**Consultation Response from KC,  
 Trees**
**2021/90377 100, Lower Town End Road, Wooldale, Holmfirth, HD9 1QD**
**Erection of two storey rear extension, single storey side extension and exterior alterations**
**Date Responded: 08/03/21 | Responding Officer: Nick Goddard | Responding Ref: CA26**

PROPOSED GROUND FLOOR PLAN  
SCALE 1:50

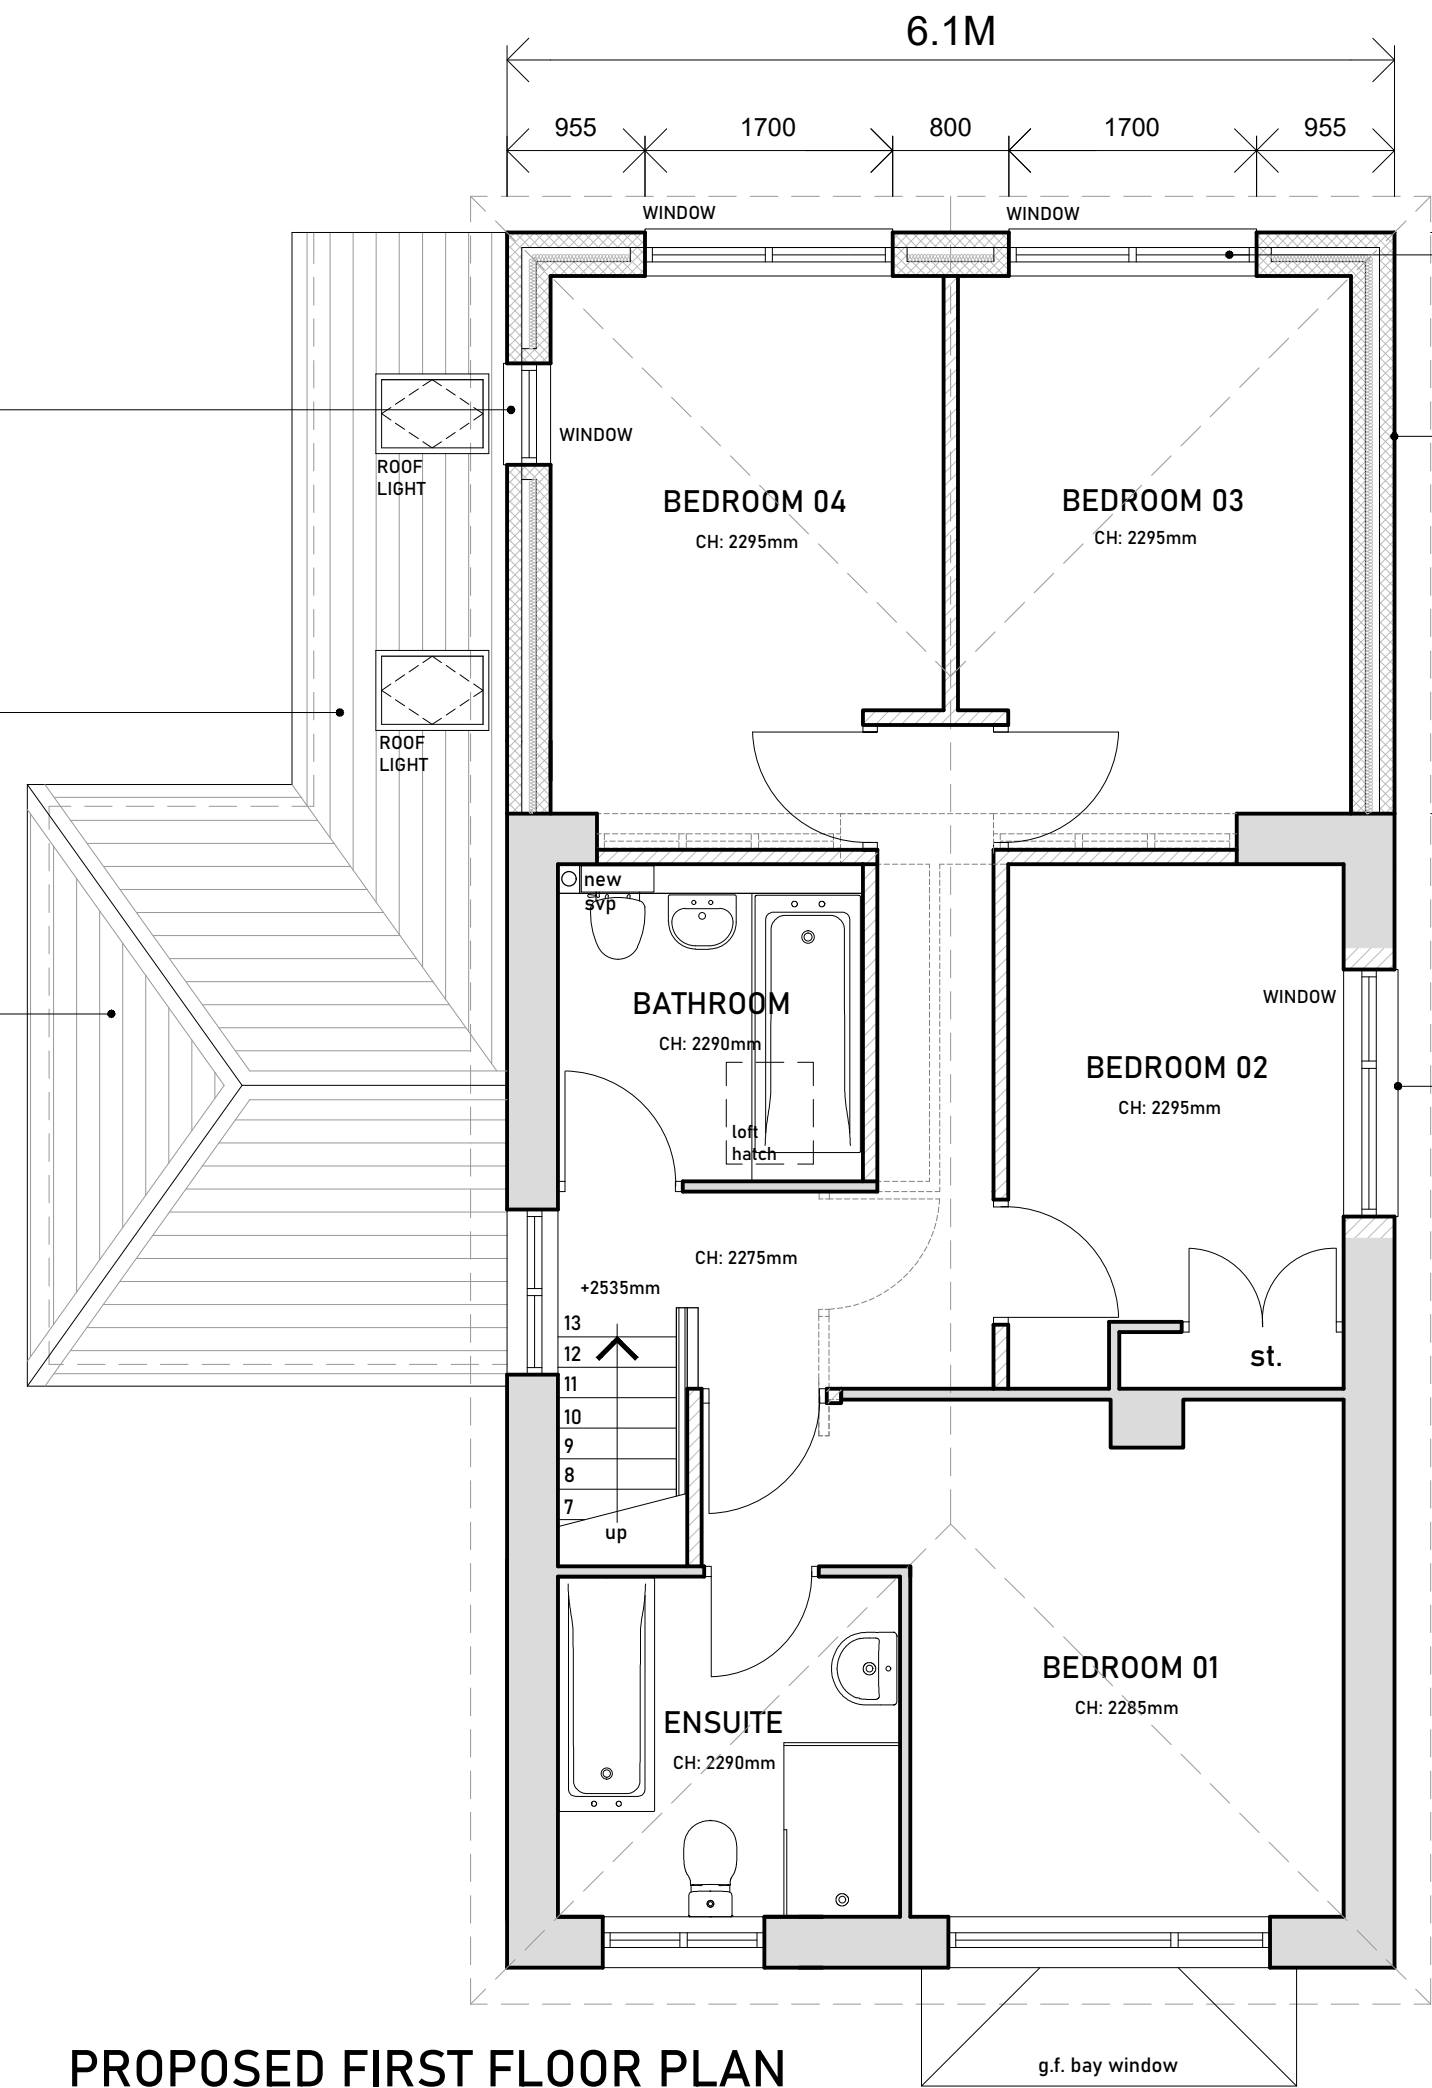
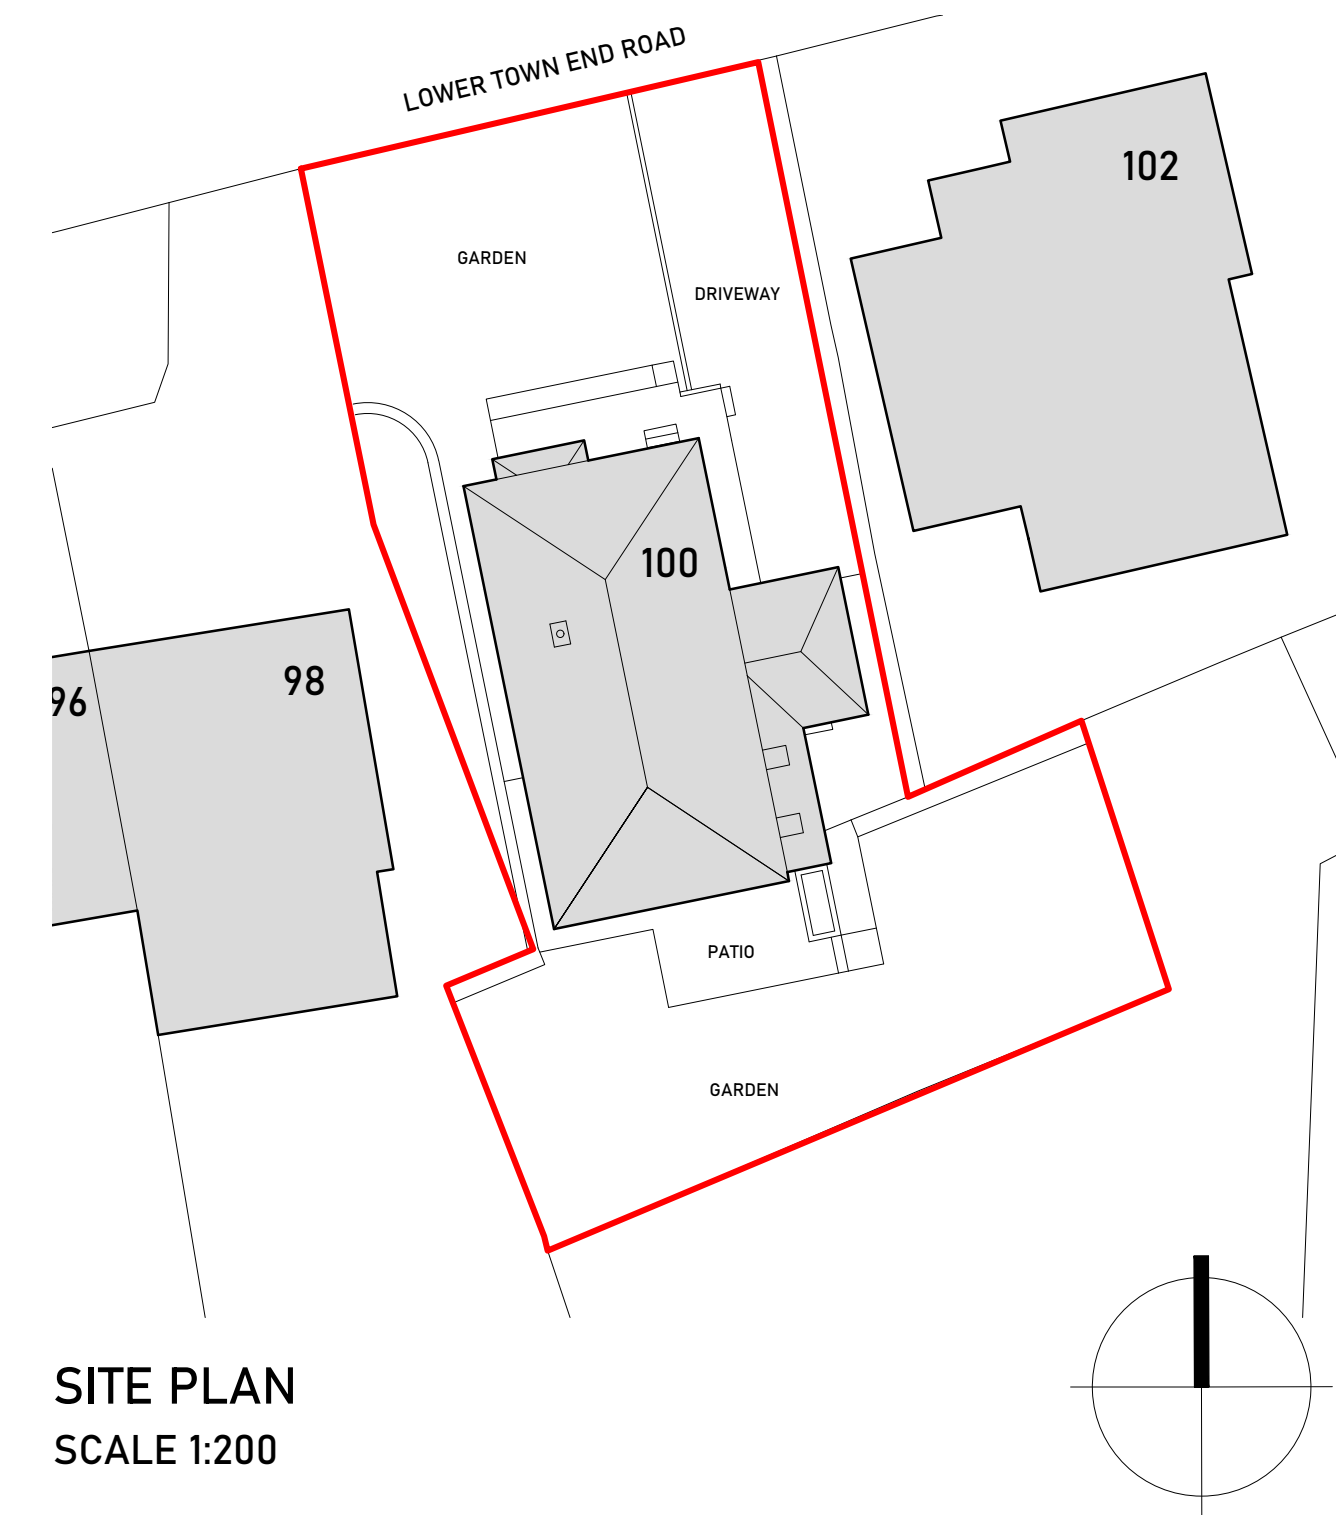
The trees on the site do not appear on any of the submitted information for this application and therefore it is not possible to fully assess the impacts they may have on the proposed extension to the rear. The proposals should have been informed and supported by a tree survey showing the extent of canopy spread, and root protection area of the trees. An impact assessment could then be made as to which trees are required to be removed and what measures are needed to retain the good quality tree on site.

At present I have concerns that the foundations for the extension may impact upon the roots of the tree; the second storey may be close to the canopy of the tree; and the proposals include a stone planter in the location of the tree which could impact upon the roots if it raises soil levels around the base of the tree.
